Case Ref: 24/00539/F	Date: 22/04/2024
From: NatureSpace	Response: Holding Objection - Further Information Required

This planning application is for *Erection of a stadium (Use Class F2) with flexible commercial and community facilities and uses including for conferences, exhibitions, education, and other events, club shop, public restaurant, bar, health and wellbeing facility/clinic, and gym (Use Class E/Sui Generis), hotel (Use Class C1), external concourse/fan-zone, car and cycle parking, access and highway works, utilities, public realm, landscaping and all associated and ancillary works and structures.*

Site Location, Ecological Designations &  
Offsite Ponds

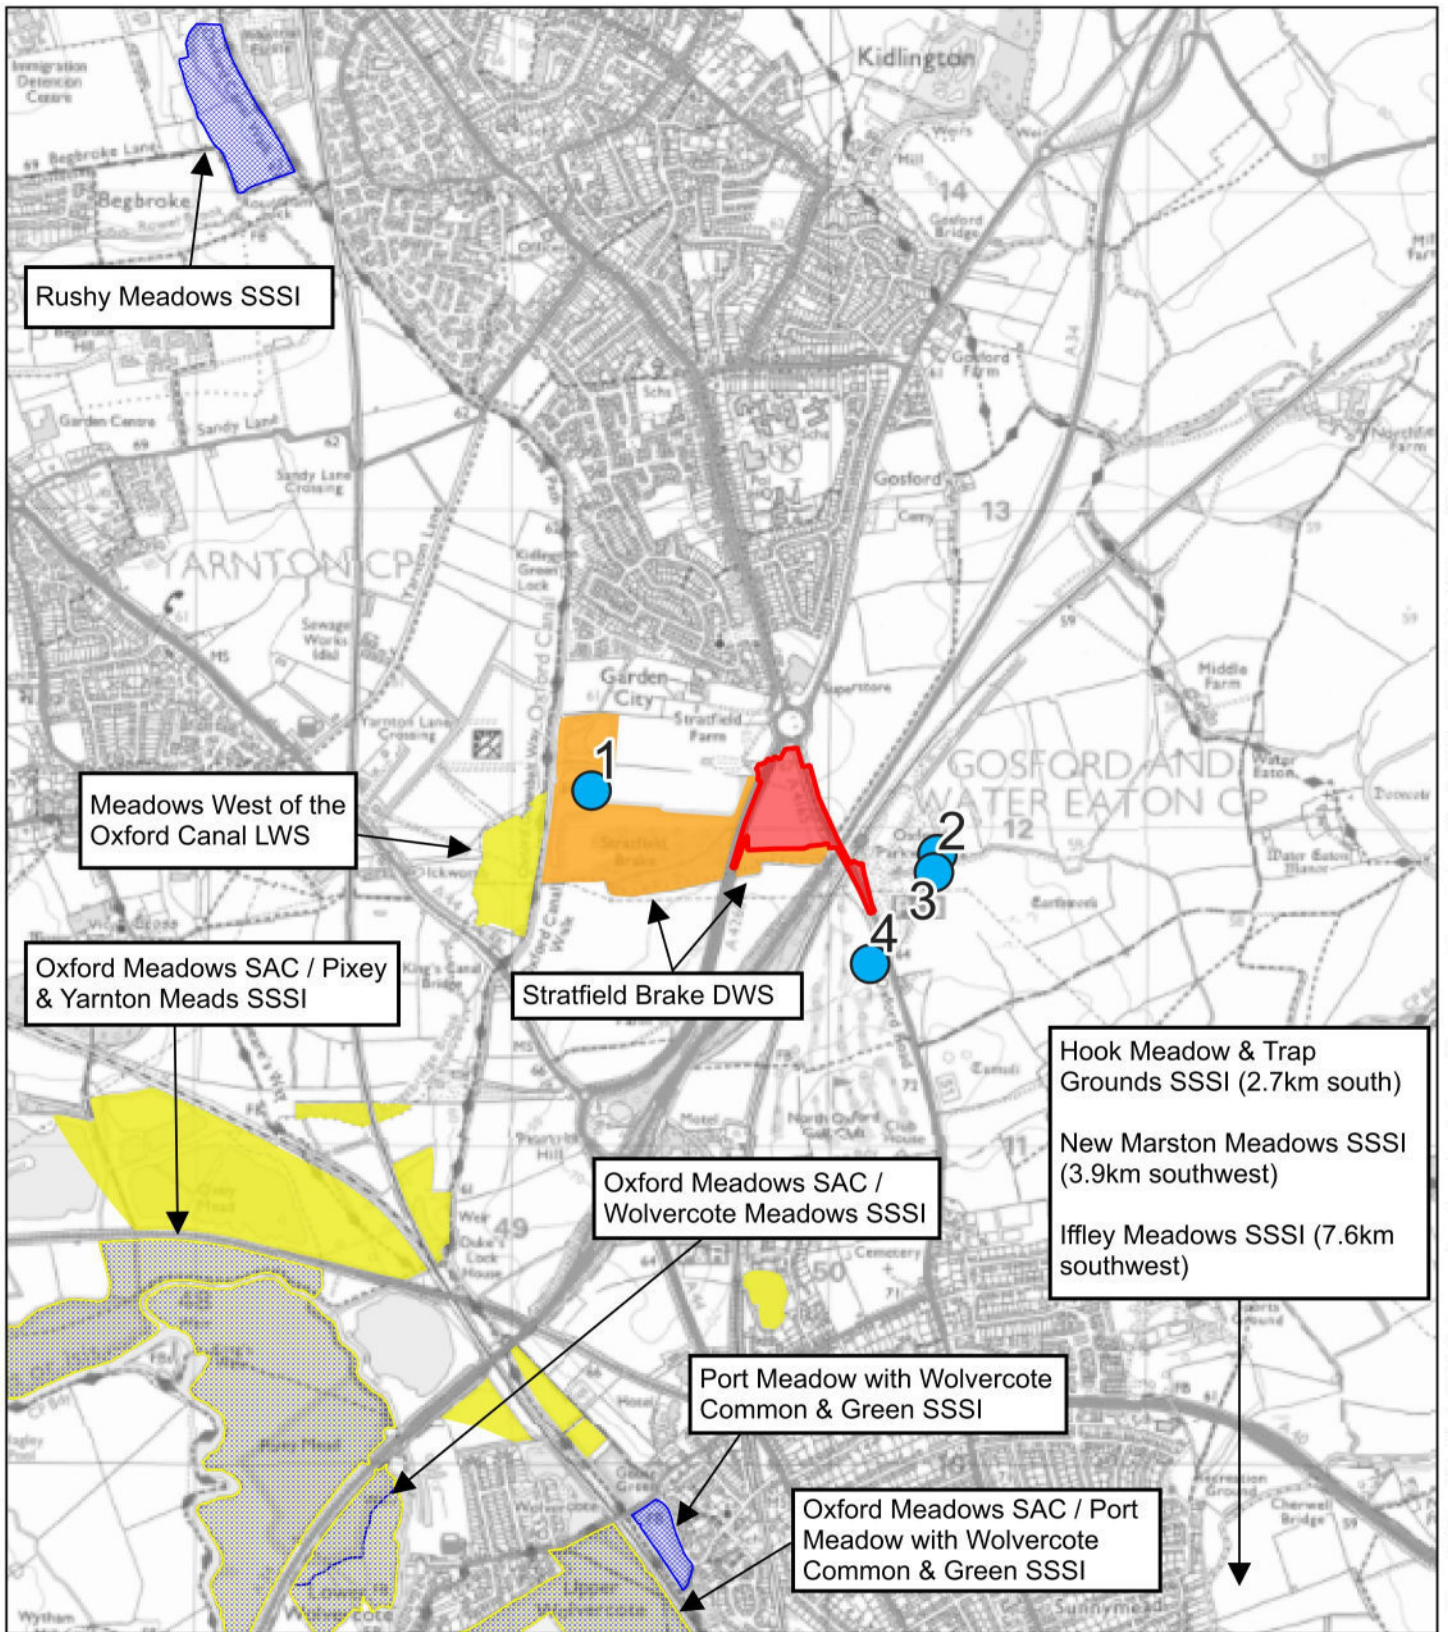
Within the Ecological Statement (ES) it was identified that there is a great crested newt record returned from P4. Our records show that there are also addition field records in the area around P4. P4 is roughly 120m from the red line boundary of the site and close to the proposed highway works.

As such I would like to request further information in the form of eDNA surveys on P2, P3 and P4 to rule out a potential impact on great crested newts. This is in line with Natural England's [Standing Advice](#).
